**Re: Valentino Estates at 9200 Wilshire Ave NE
Erosion and Sediment Control Plan
Engineer's Stamp Date 7/30/2024 (C20E089)**

Based on the information in your submittal, received on 8/14/24, the above-referenced ESC Plan can not be approved for Grading and Work Order until the following comments are addressed.

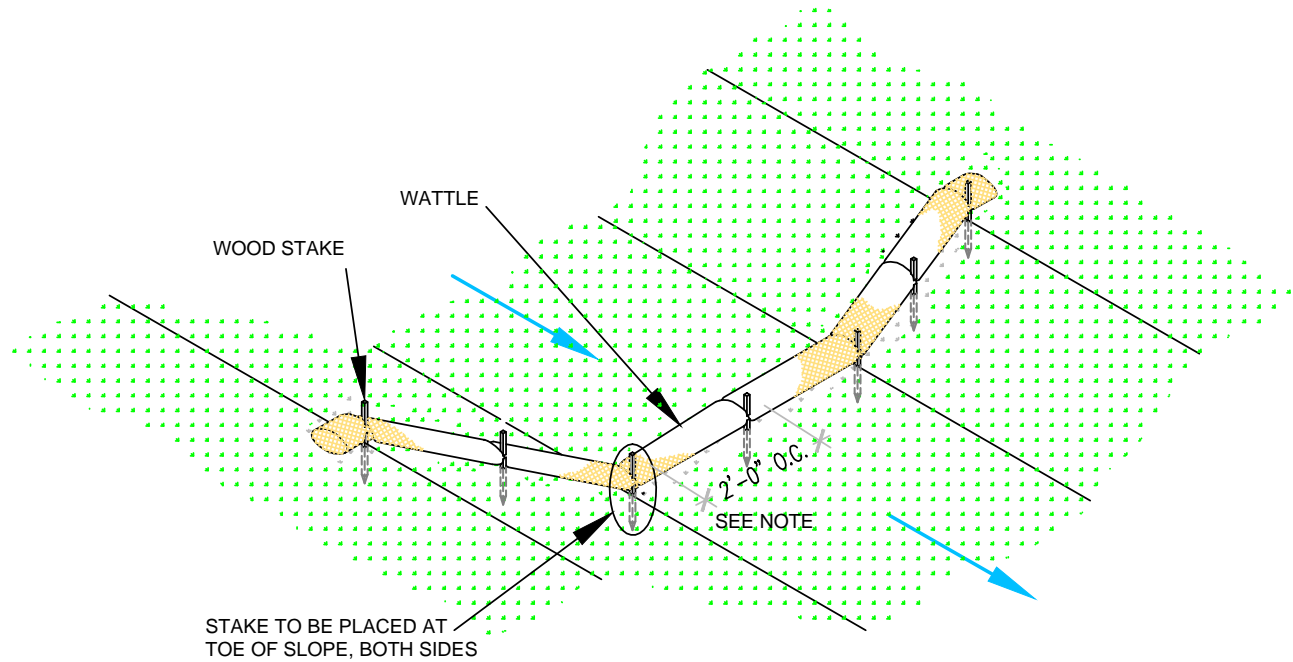
2. The cutback curb detail is on sheet 6 of the plans but isn't identified in the legend or as one of the stormwater controls on the SWPPP map. Some type of perimeter control is needed between the lots and the street from when the grading and infrastructure are complete until house construction is complete. These BMPs are required when the infrastructure is complete and at the beginning of the building permit construction. The transition between these two phases may vary, and the transfer of each lot from one operator to the other doesn't necessarily have to happen simultaneously, but the SWPPP Map must be kept up to date during construction and indicate the area of control of each operator as it changes. Separate SWPPP Maps are recommended for the two phases: Work Order and Building Permits. The map should show the locations where the sidewalk and landscape swale per DWG 2414 are included with the infrastructure construction. Where sidewalks preclude the cutback curb, use a silt fence or mulch sock behind the sidewalk instead.
